# CITY OF ALBUQUERQUE

**Re: The 66**  
**4501 Central Ave. NE**  
**Traffic Circulation Layout**  
Architect's Stamp 03-06-23 (K17-D125)

Based upon the information provided in your submittal received 10-26-23, the above referenced plan cannot be approved for Building Permit until the following comments are addressed:

SITE PLAN

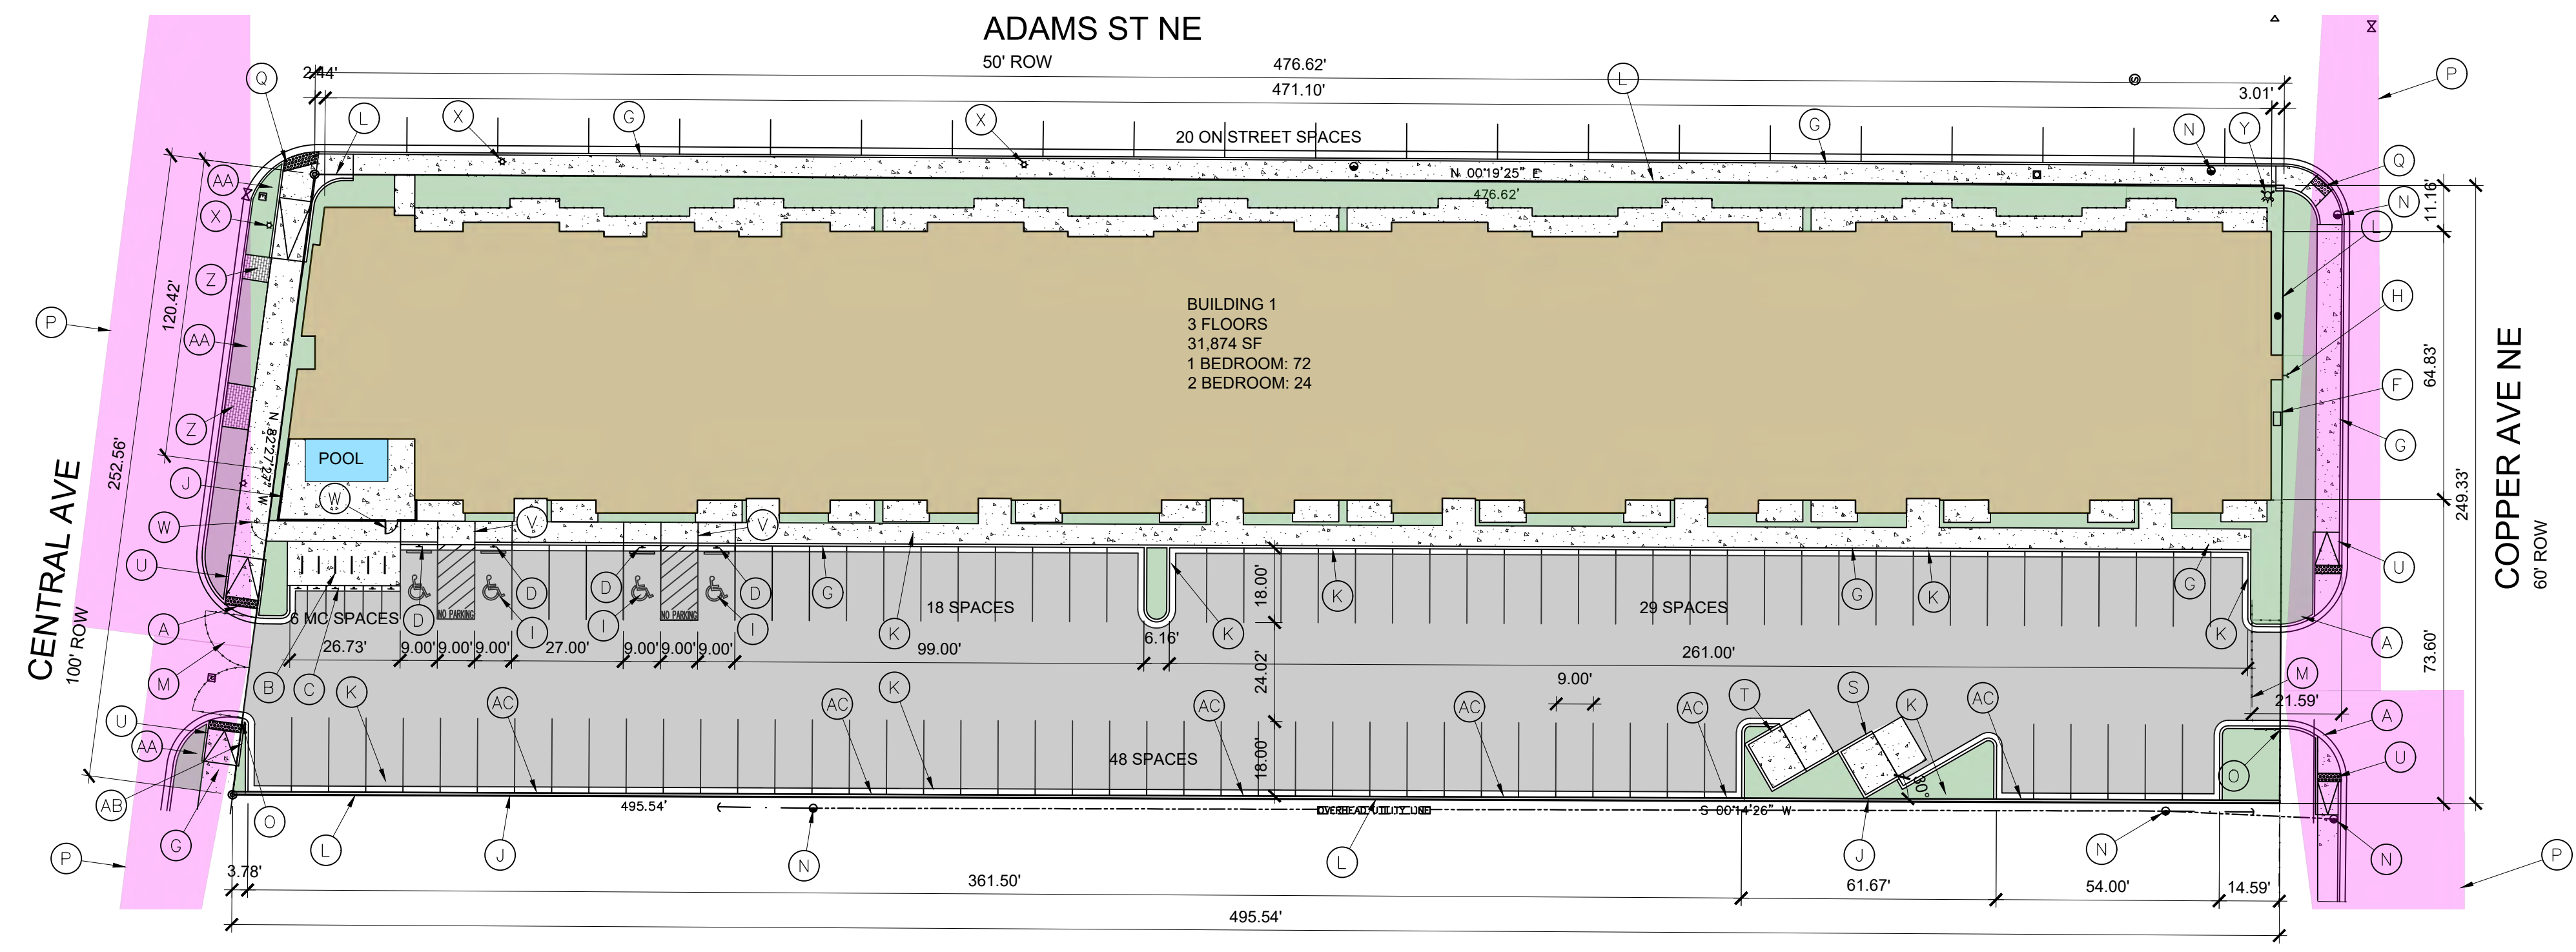
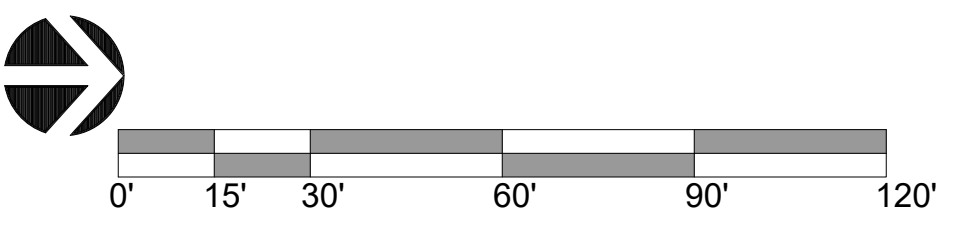
1. Identify all existing easements.
2. Proposed Site access off Central Ave.:
  - please provide width and show the radii on the site plan.
  - Minimum throat depth should be 50 ft. please show this dimension on the site plan.
3. Proposed Site access off Copper Ave:
  - Provide width and show the radii on the site plan.
  - Please show on the site plan a vehicle turnaround template to ensure there will be no backup to the public right of way.
4. Key note X: A minimum 4 ft. wide pedestrian path should be shown around each of the poles; please show these dimensions on the site plan to ensure that a minimum 4 ft. wide path is obtained.
5. Please show main entrance and the doors way.
6. Please revise site plan, key note K refer to curb and gutter.

7. Please explain, what is this?

8. Please show on the site plan a minimum 20 ft. long no parking zone on Adams St. at the corner of Adams St. & Central Ave. and Adams St. & Copper Ave.

9. The pavement marking "MC" should be shown in the opposite direction for motorcycles entering the parking space.
10. All one-way drives shall have "One Way" and "Do Not Enter" signage and pavement markings. Please show detail and location of posted signs and striping.
11. Please show legend on the site plan.
12. Unused curb cuts must be replaced with sidewalk and curb & gutter. A build note must be provided referring to the appropriate City Standard drawing.
13. Please provide a letter of response for all comments given.
- Once corrections are complete resubmit
1. The Traffic Circulation Layout
  2. A Drainage Transportation Information Sheet (DTIS)
  3. Send an electronic copy of your submittal to [PLNDRS@cabq.gov](mailto:PLNDRS@cabq.gov).
  4. The \$75 re-submittal fee.
